Friends of Carrington Moss (20048873) Response to ExQ1 Submission to Deadline 3: Tuesday 5 November 2024.

**FIGURE 14.3**

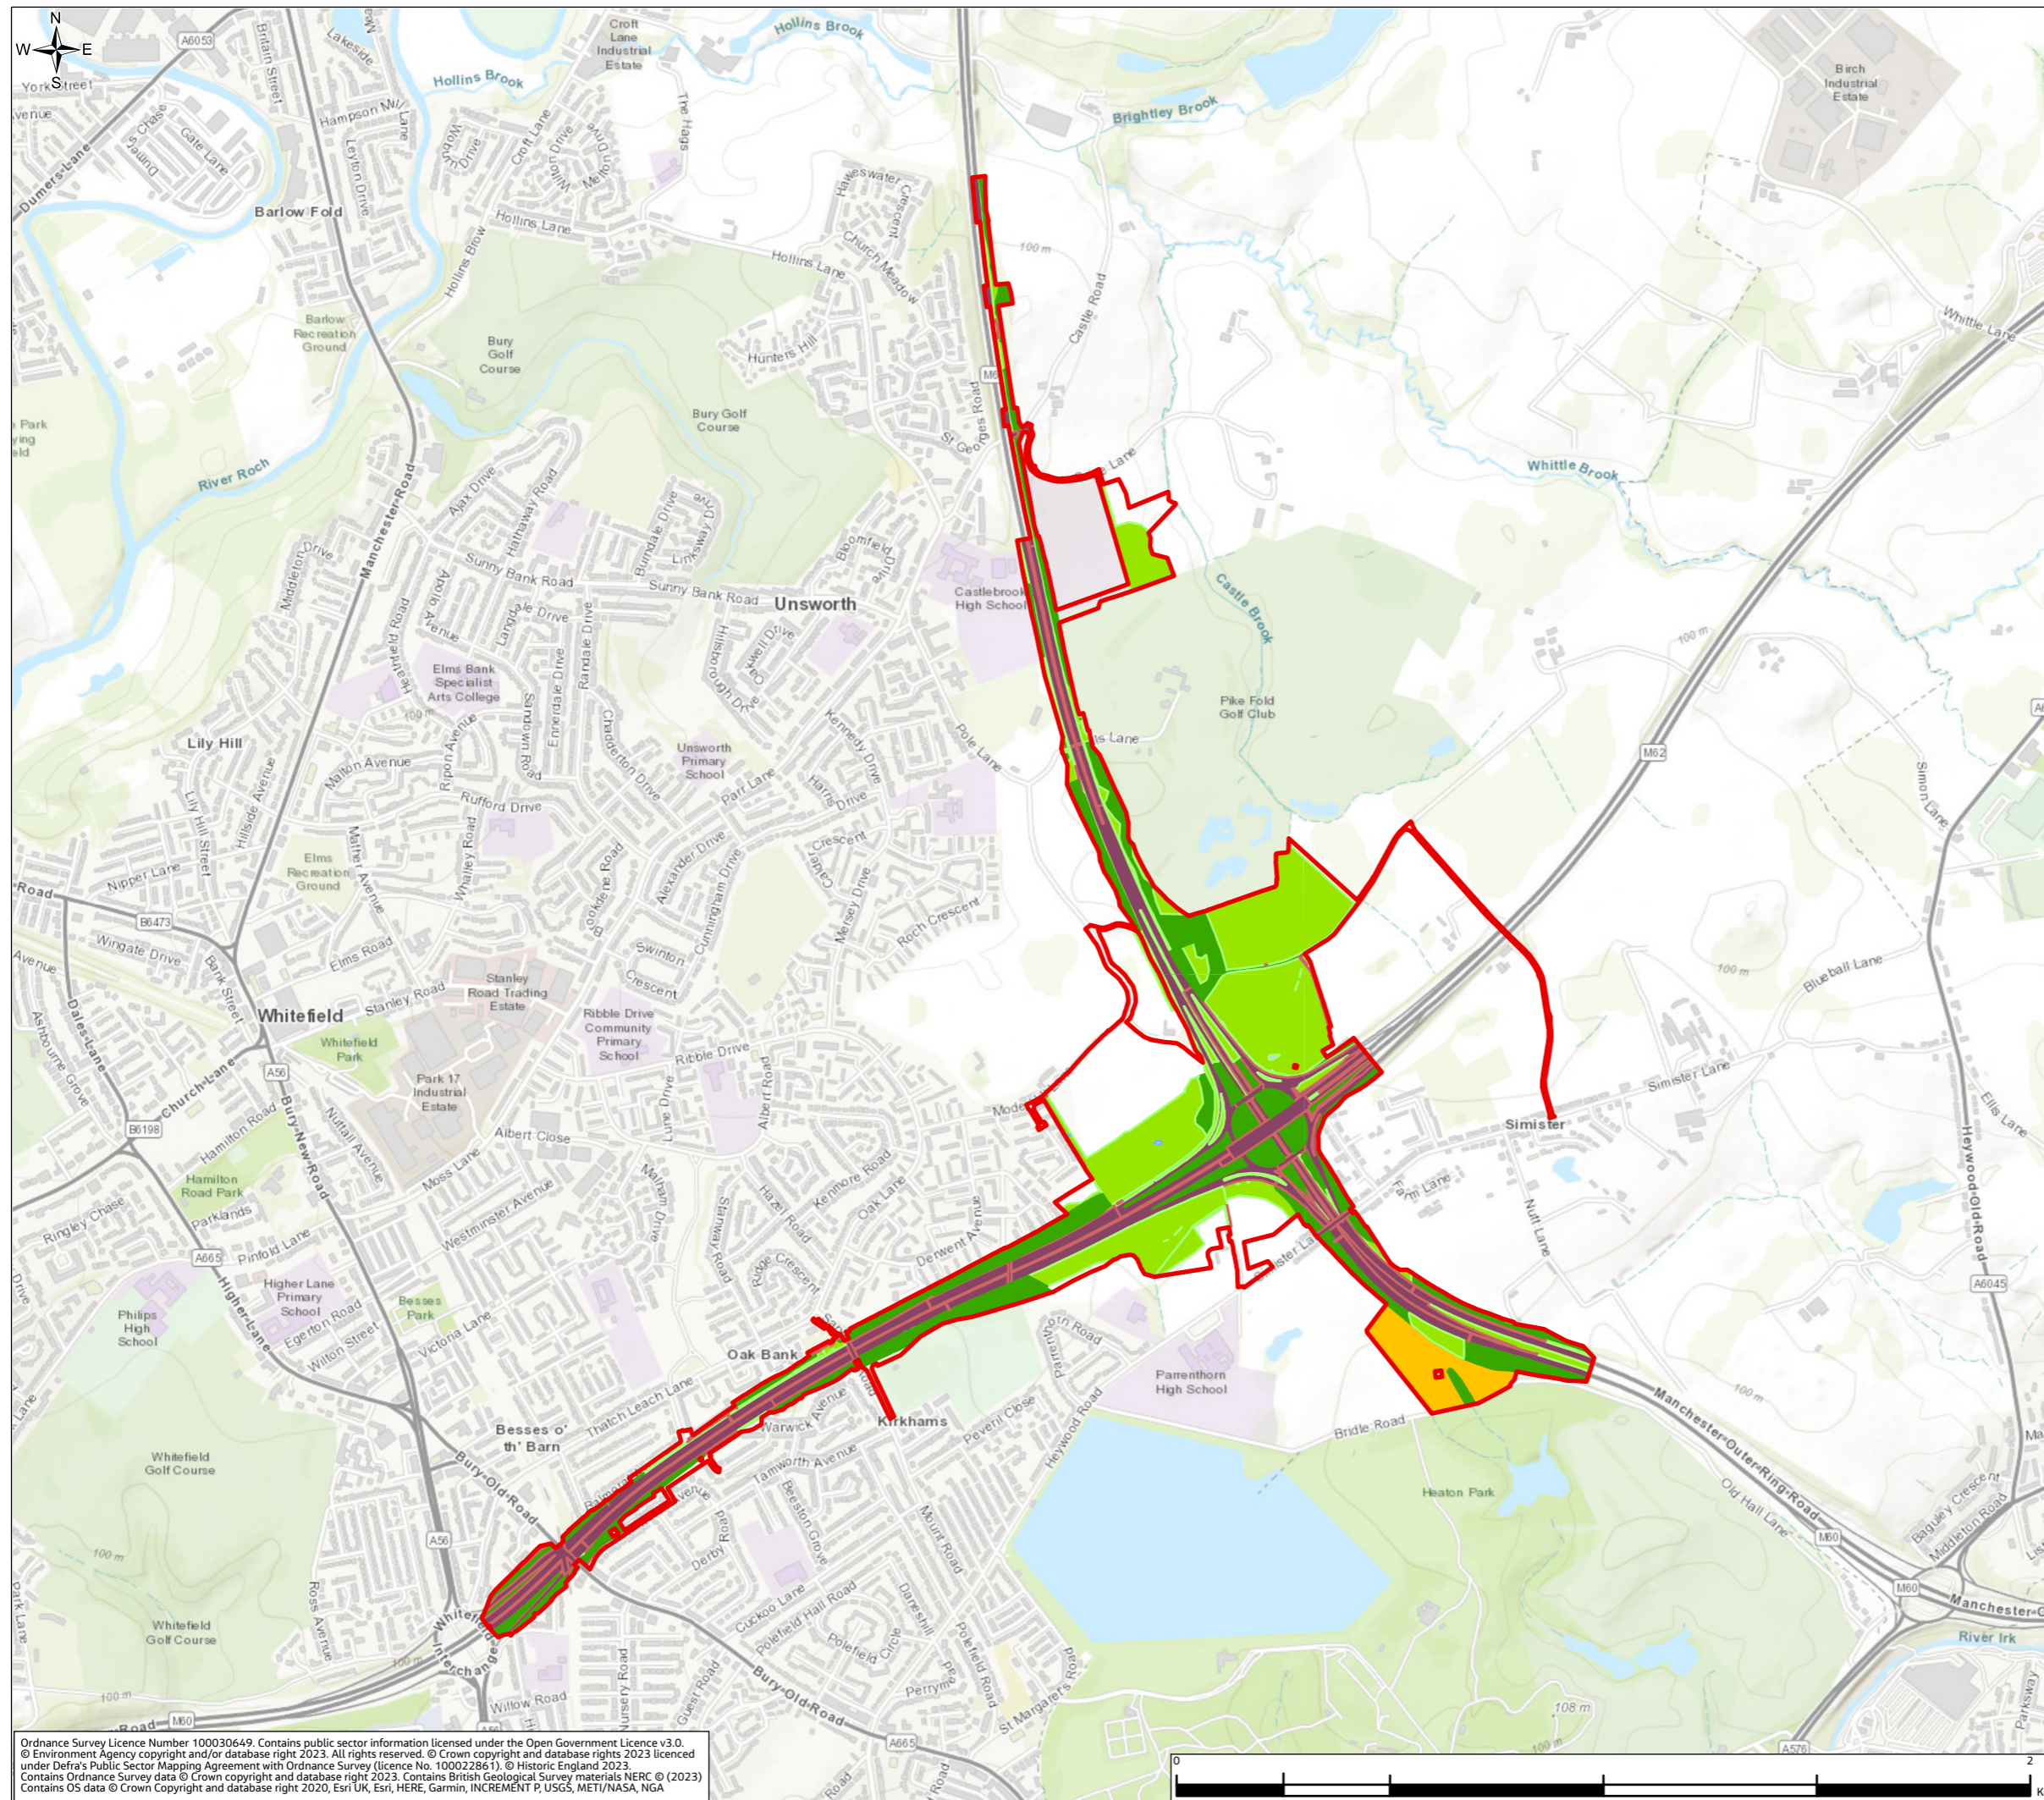
It is challenging to determine whether we agree with the methodology and assessment findings set out in ES Chapter 14 because we just have summary figures, the detailed calculations are not revealed. So, whilst we can assume it is a competent piece of work, we do question some of the assumptions made:

- The assessment confirms that the scheme will lead to an increase in carbon emissions, of some 62 kTonnes. The assessors argue that this is miniscule against the UK carbon budget. This is poor reasoning because, whilst it is numerically correct, it does not consider the cumulative impact of all such developments in relation to achievement of the national target. If every development nationwide produces a small increase in carbon emissions, how can net zero be achieved?

For a more local comparison, the figure represents circa 0.09% of the 67 Megatonnes in Greater Manchester's carbon budget, which the monitoring reports suggest is already being seriously exceeded (see page 18 of the latest progress report⁸ "*The latest data show GM emitted 11.2Mt of CO₂ in 2021, an increase (worsening) from the previous report at 10.7Mt of CO₂*" and the emissions dashboard⁹, for which the latest data shows that GM is over the carbon budget by 21.3 MtCO₂).

- It does not appear that any allowance has been made for the opportunity cost of lost carbon sequestration as a consequence of land sealing.
- It is unclear whether carbon emissions from the anticipated induced traffic have been included within the calculations. This is particularly important given the significant level of development proposed in the now adopted Places for Everyone Plan. Given the lack of sustainable passenger (rail/tram) and freight (rail/water) transport proposed in that Plan, the carbon emissions associated with the consequential huge increases in traffic should be taken into consideration.

- Whilst the assessment highlights the quantitative analysis that has been undertaken, there needs to be more qualitative analysis to ensure the scheme is compliant with national, regional and local policies designed to reduce cumulative emissions.
